Application for Removal or Variation of a Condition following Grant of Planning Permission or Listed Building Consent

Erection of new entrance foyer and single storey side extension, including new access path and ramp.

10494/APP/2024/1634

variation of condition #2

Drawn By	LL	Date	Dec 2023
Checked By	JS	Date	04.12.24
Approved By	JS	Scale	100 / 50 @A1
Drawing No.		Rev.	
5530-PL-103			B

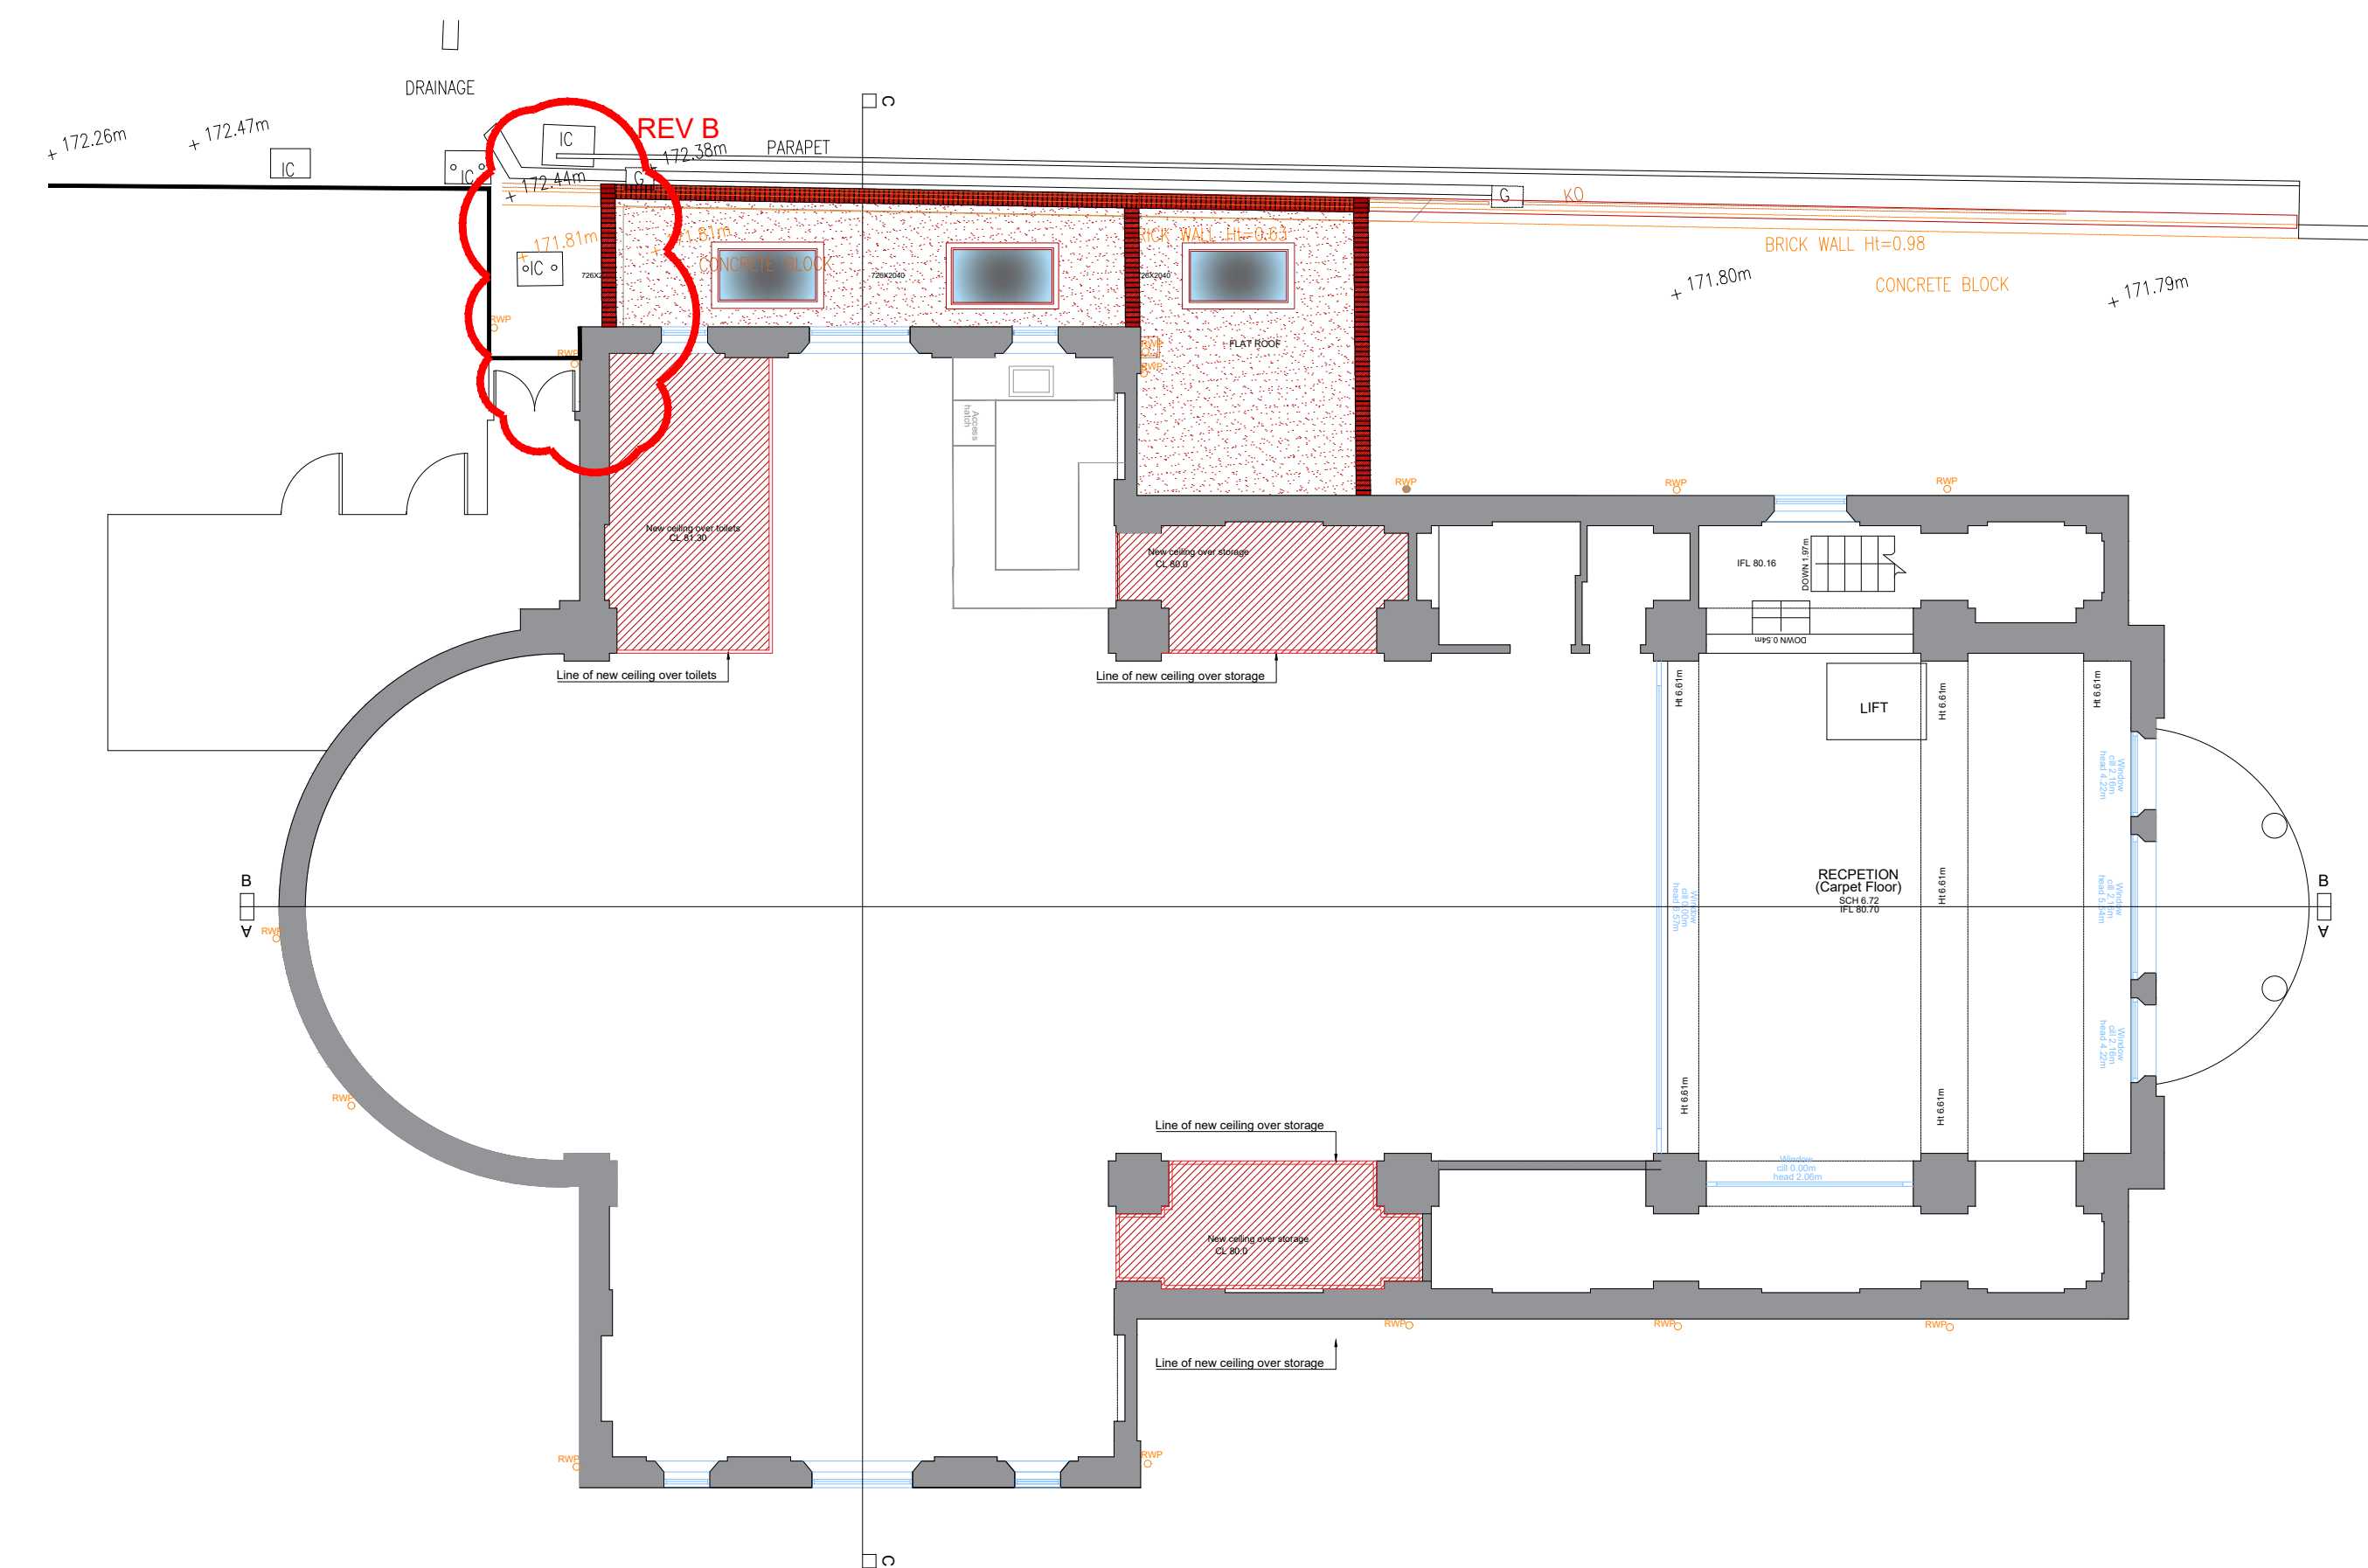
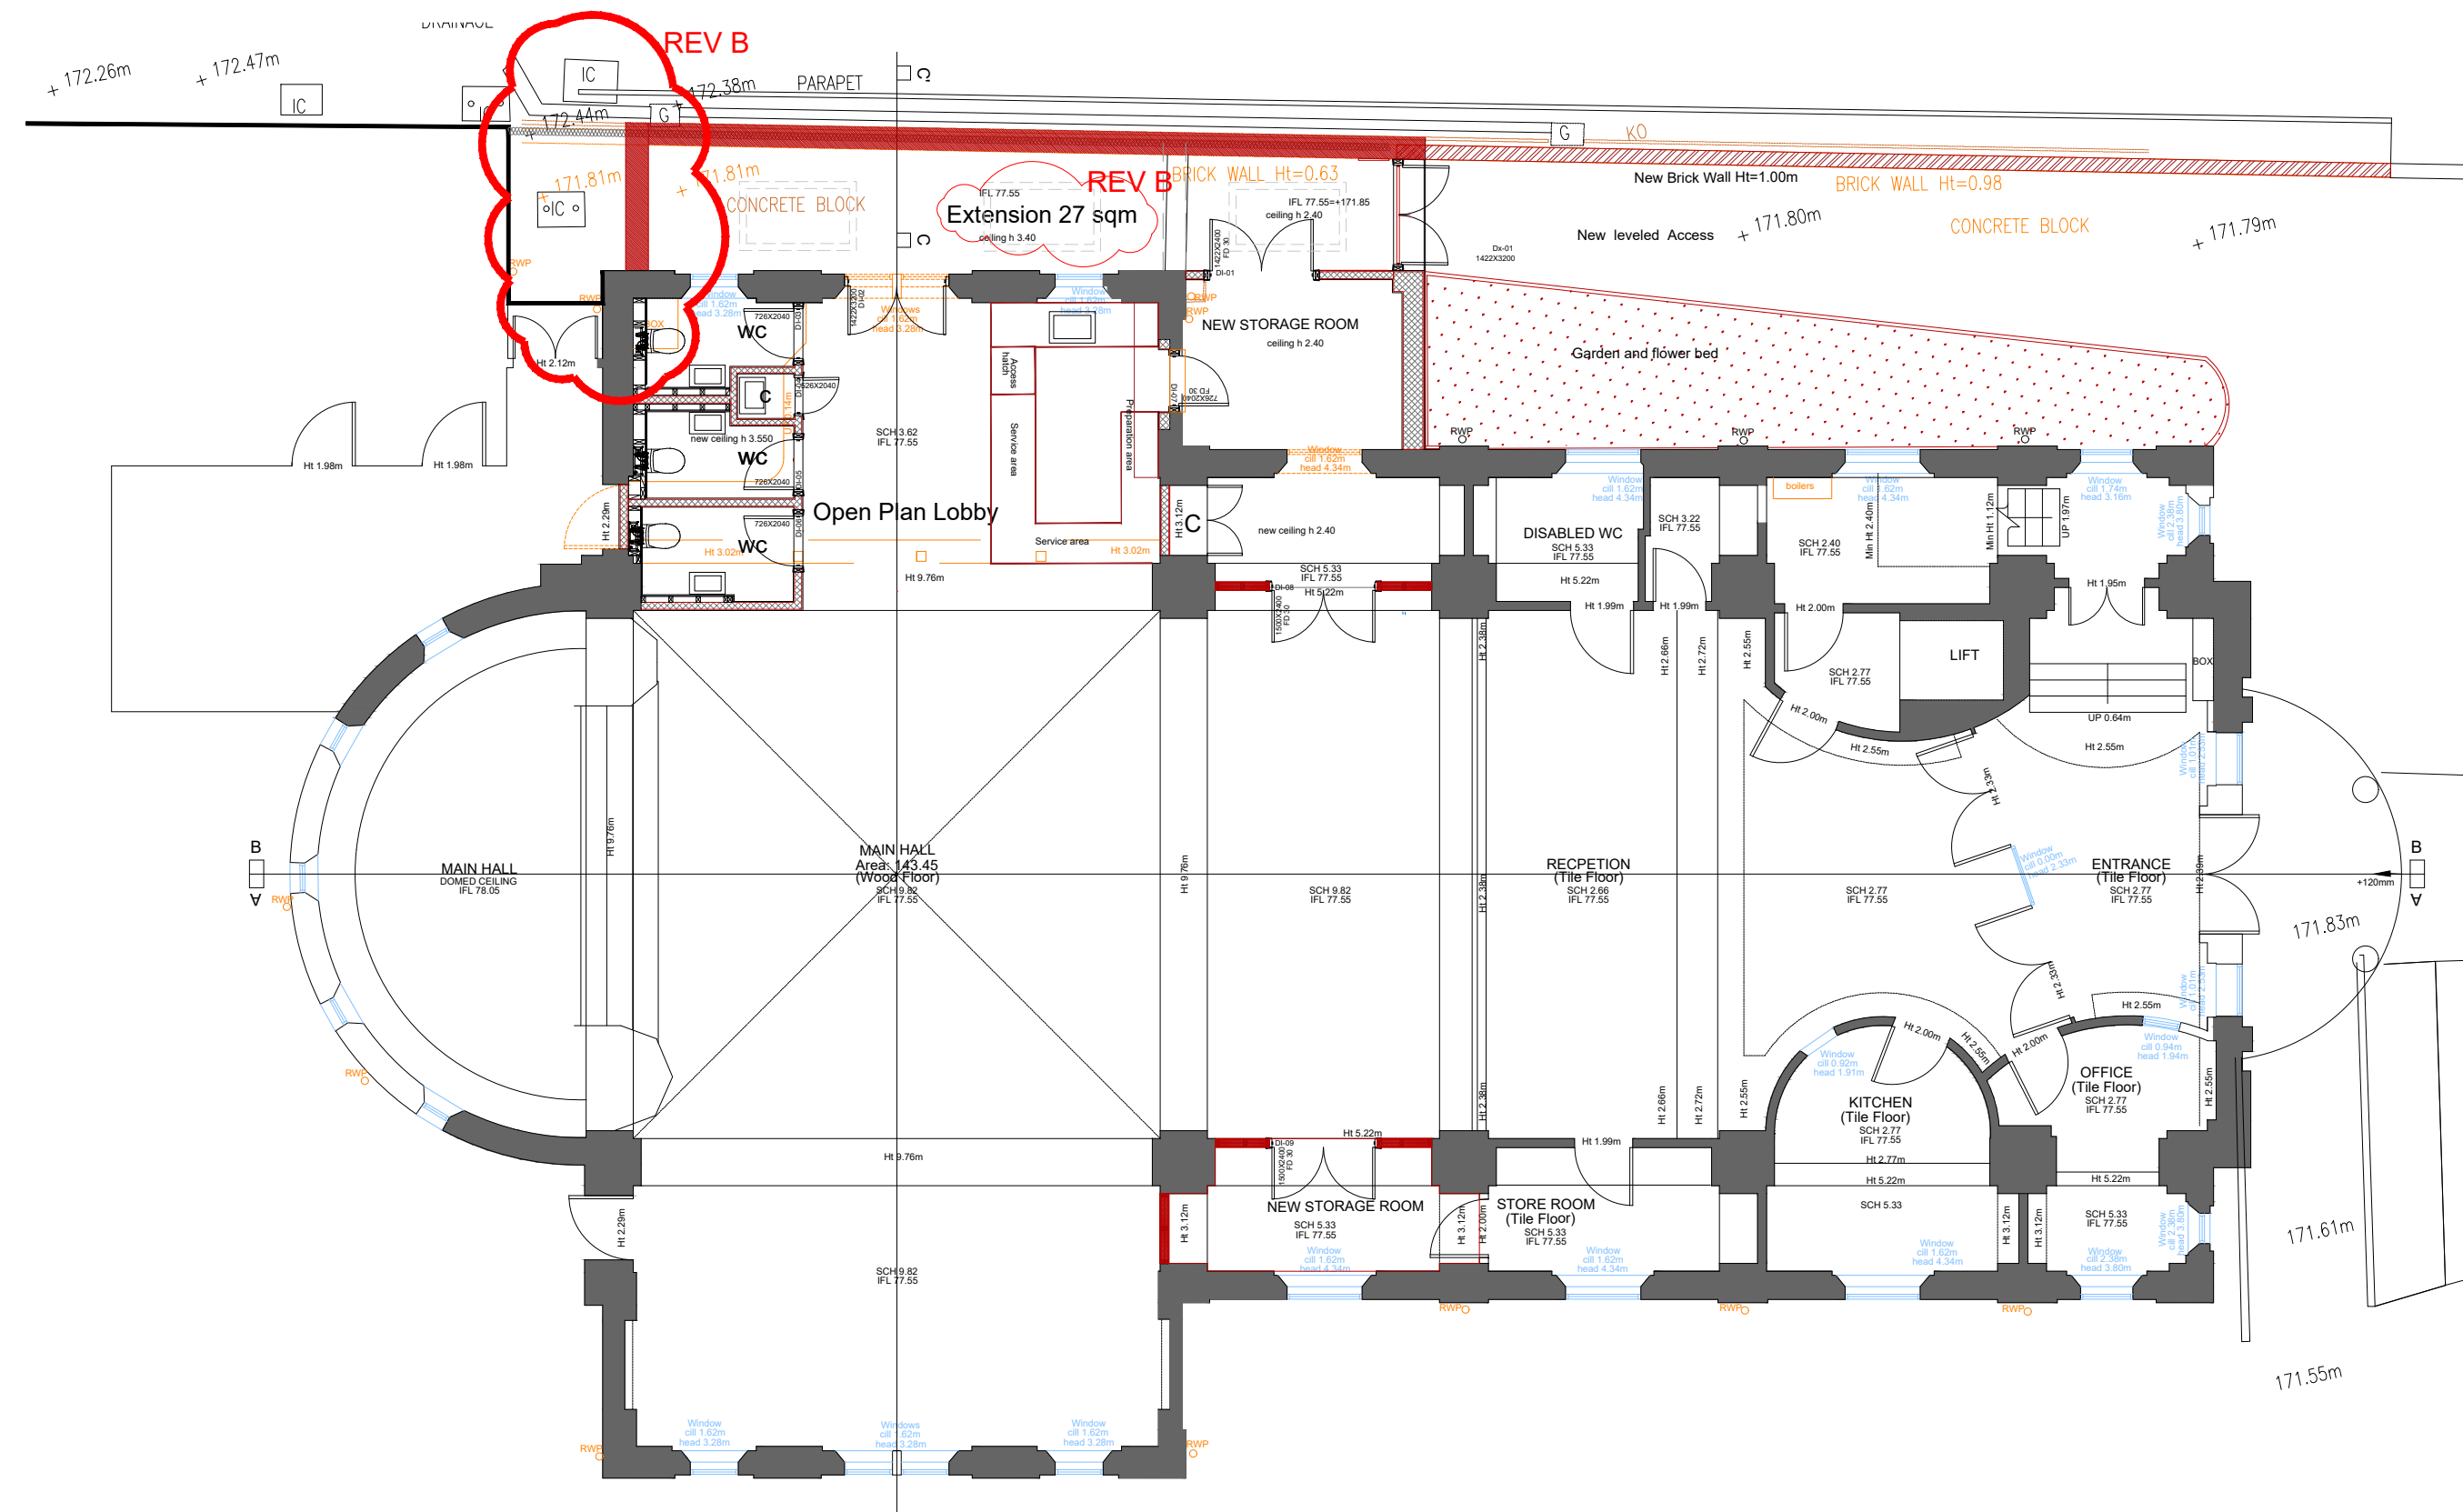
Due to Thames Water constraints

It is necessary to reduce the extension length, add a door at the opposite end, and leave the existing public manhole near the rear building outside the new extension

5530-PL-103 A for the new updated drawing 5530-PL103 B
